SADDLEHORN RANCH - FILING 5

PRE-DEVELOPMENT GRADING AND EROSION CONTROL PLANS

EPC STORMWATER REVIEW COMMENTS
IN ORANGE BOXES WITH BLACK TEXT

PCD-ENGINEERING REVIEW COMMENTS
IN BLUE BOXES WITH BLUE TEXT

GRADING AND EROSION CONTROL PLANS - FILING 5
 GRADING & EROSION CONTROL PLANS
 SHEET 5 OF 9
 JOB NO. 25142.07

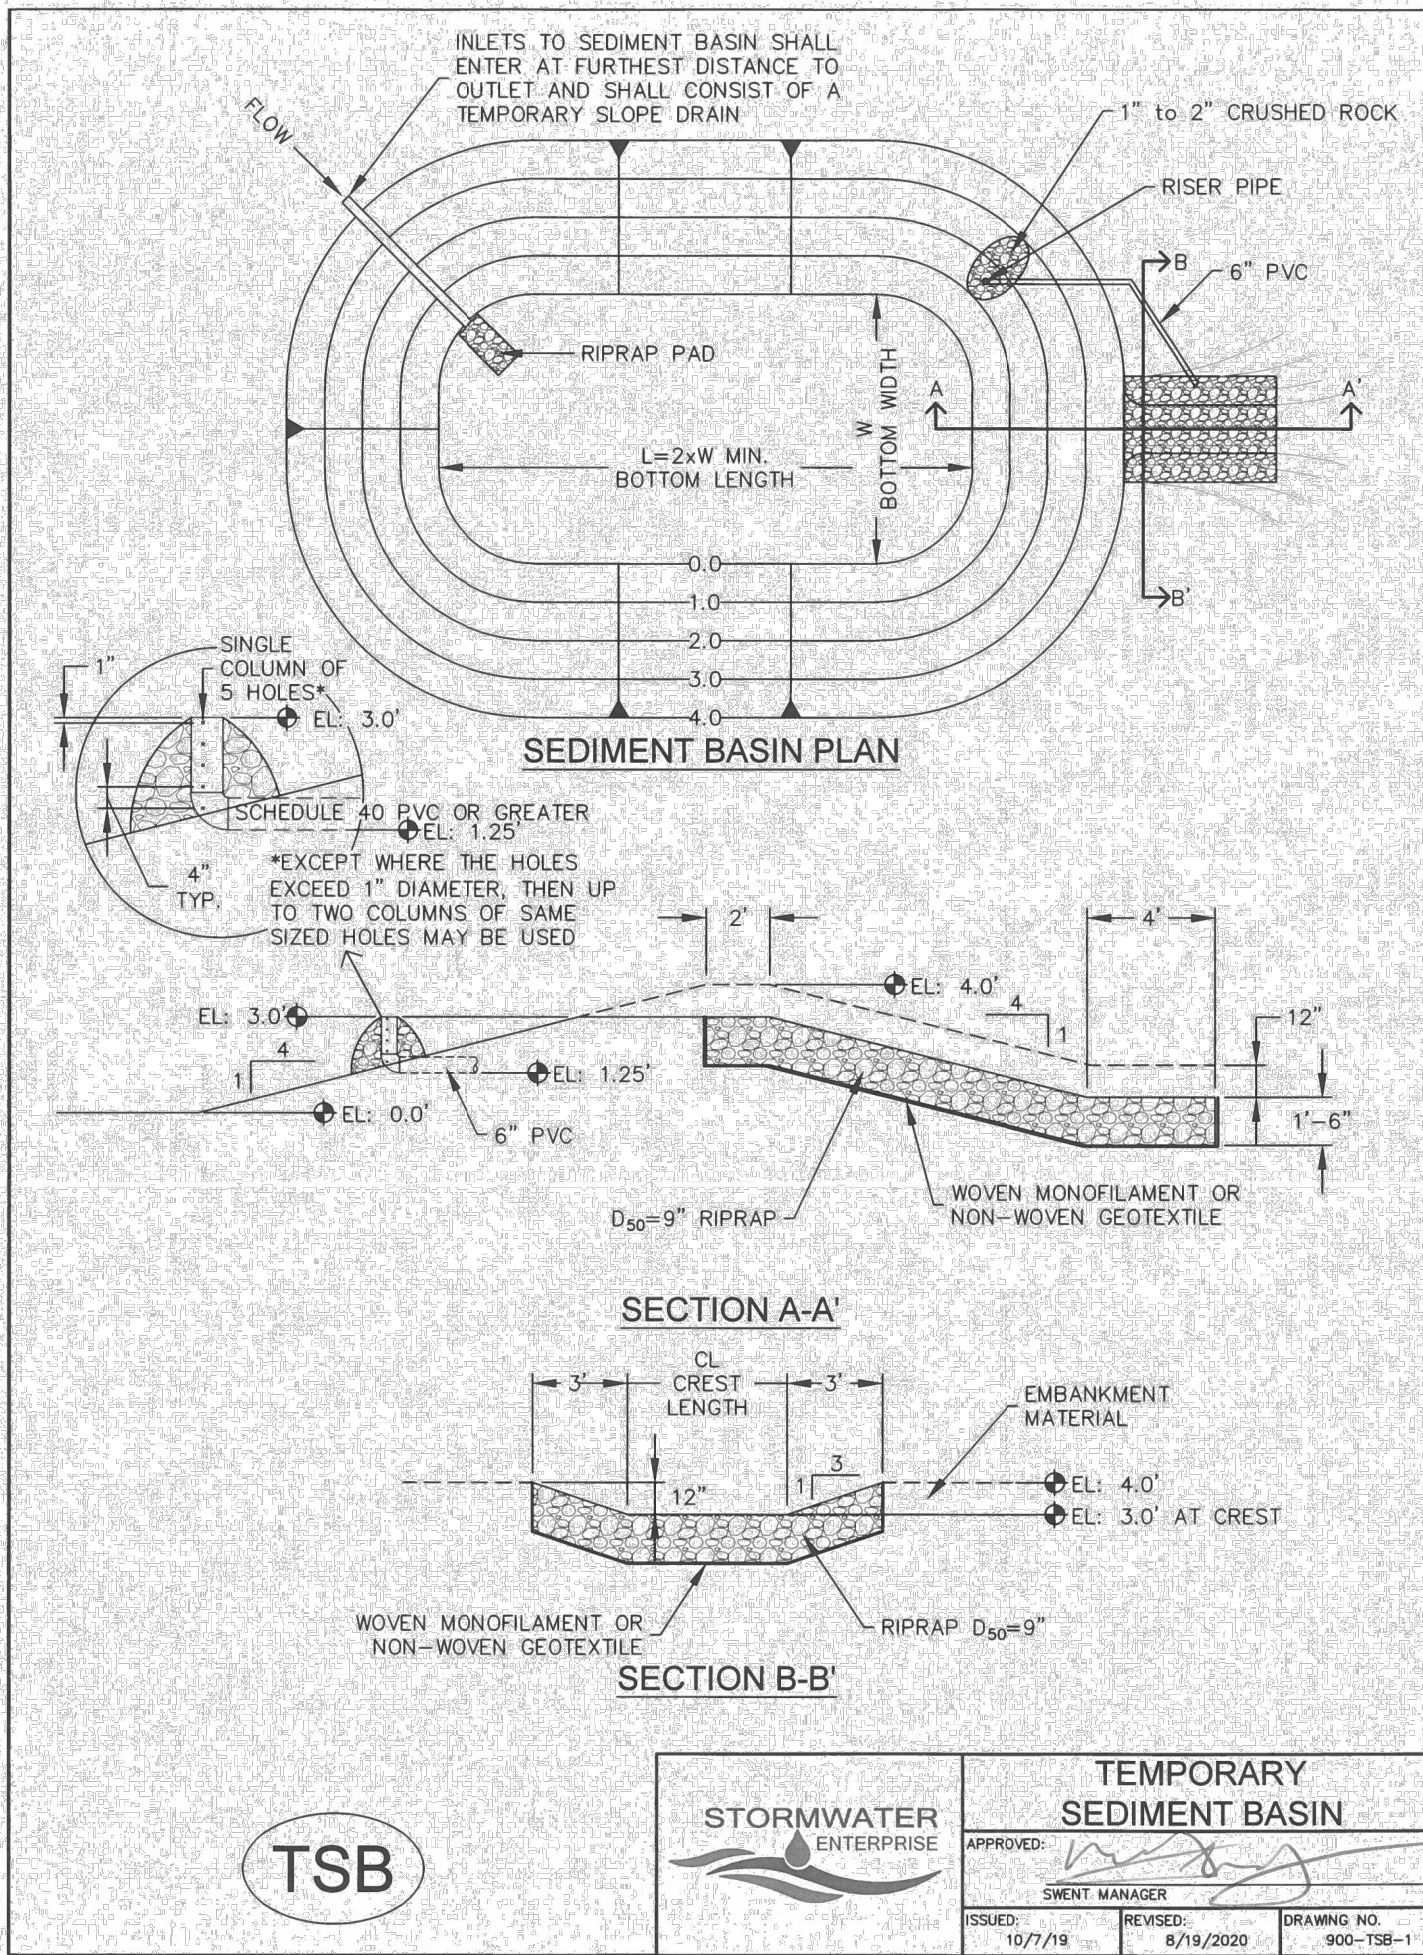
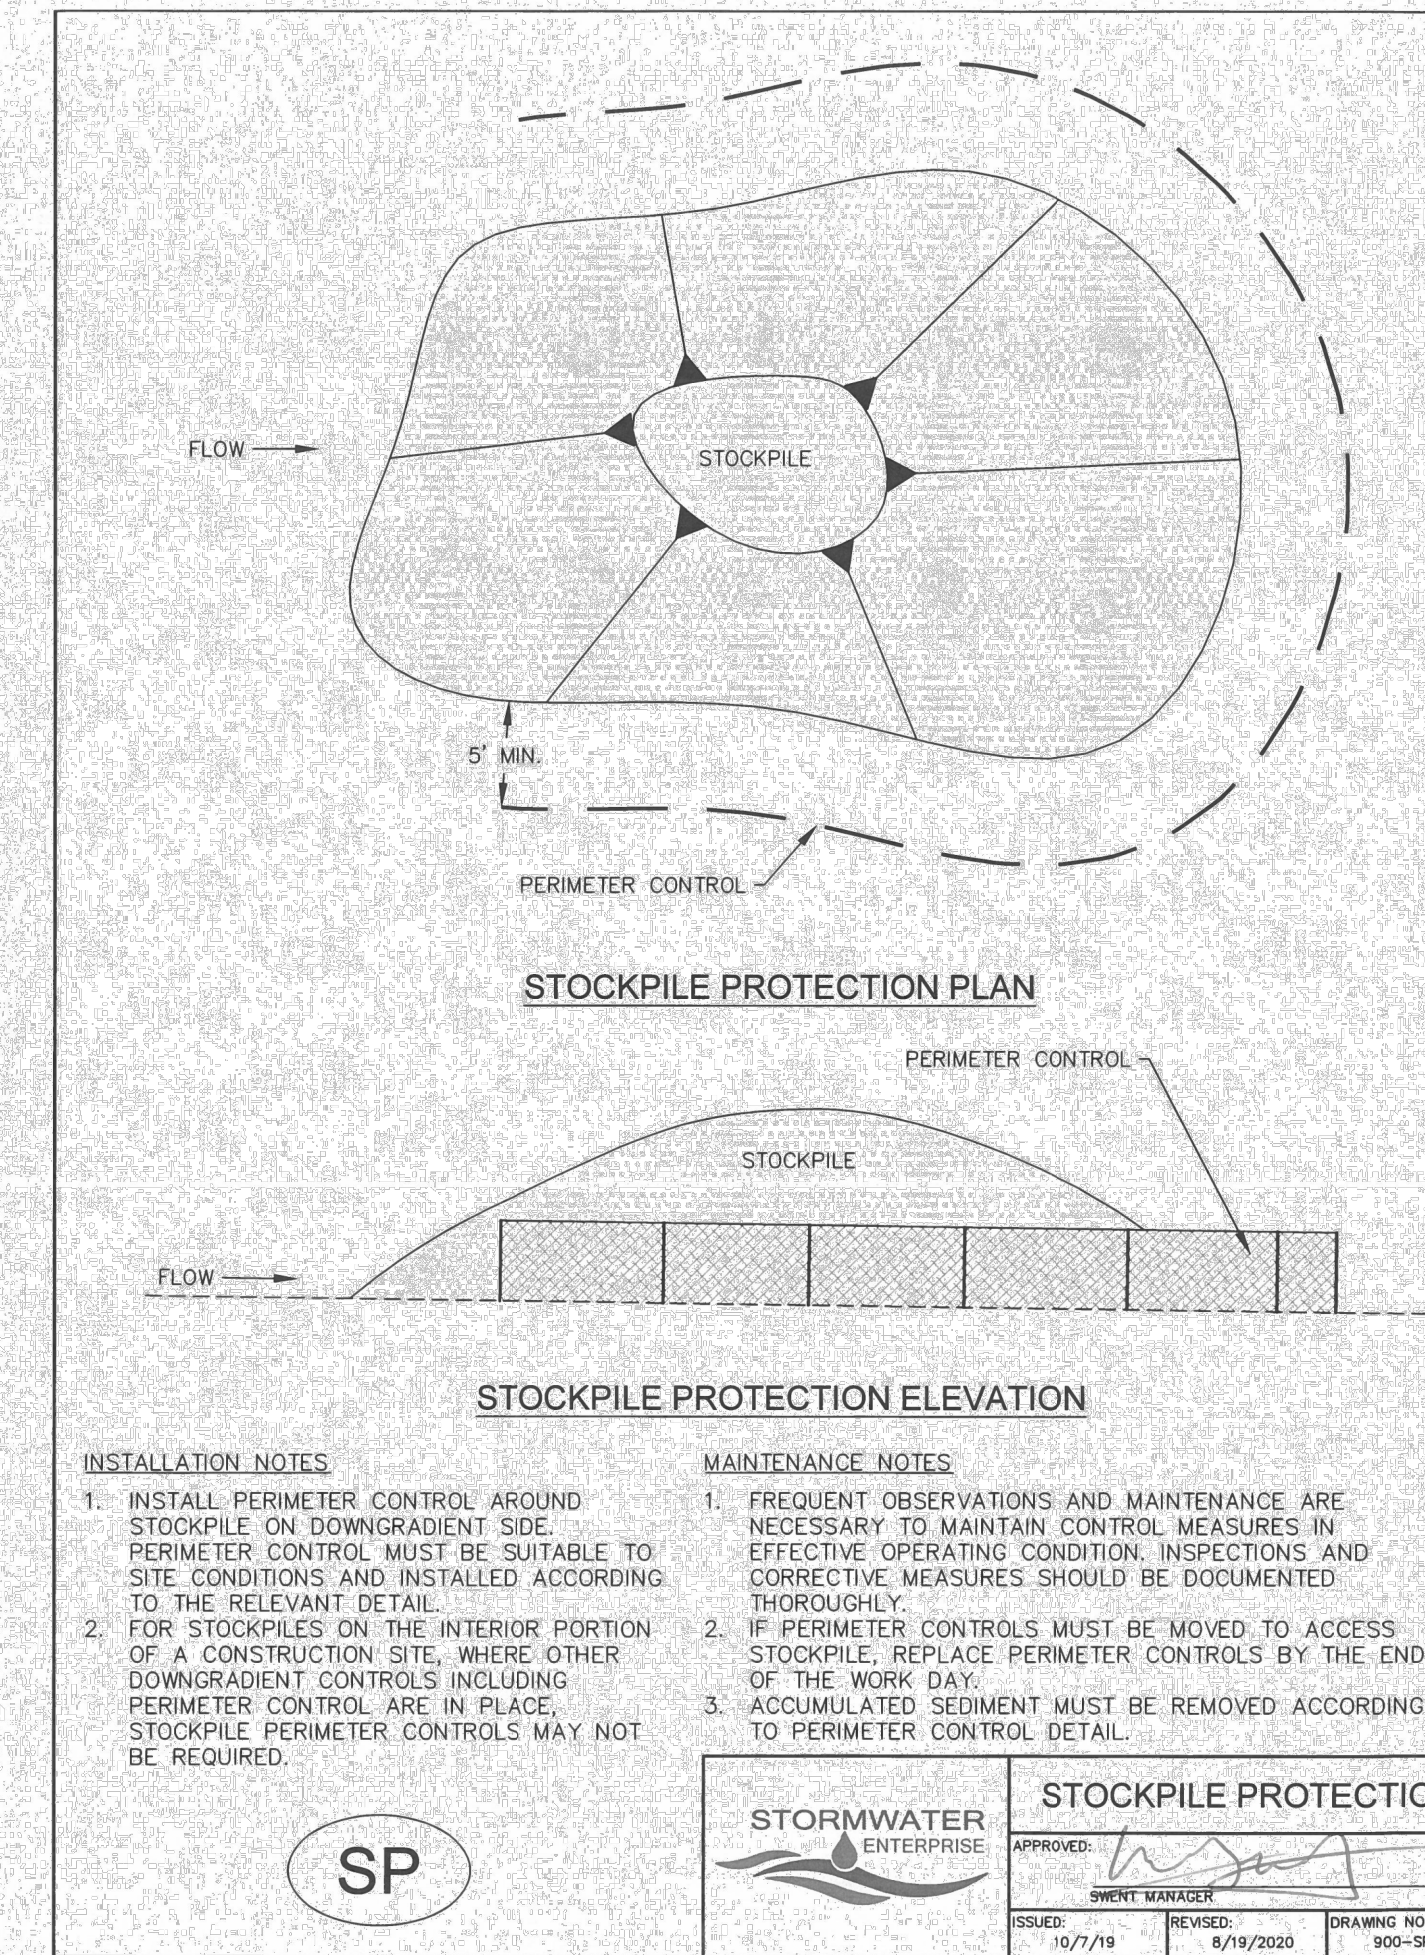
Call out grading in the SFHA and discuss permitting with the Regional Floodplain Administrator

Is an offsite easement required?

show the TSB spillway location

show the TSB spillway location

EXISTING DRAINAGE ARROW
Spillway should be on this side to minimize impacts to downstream property
PROPOSED DRAINAGE ARROW

Need owner permission to grade offsite. Provide copy of owner permission to EPC.

add silt fence

since this is an EGP, remove this bullet and keep BMPs in place for subsequent construction

show on plans
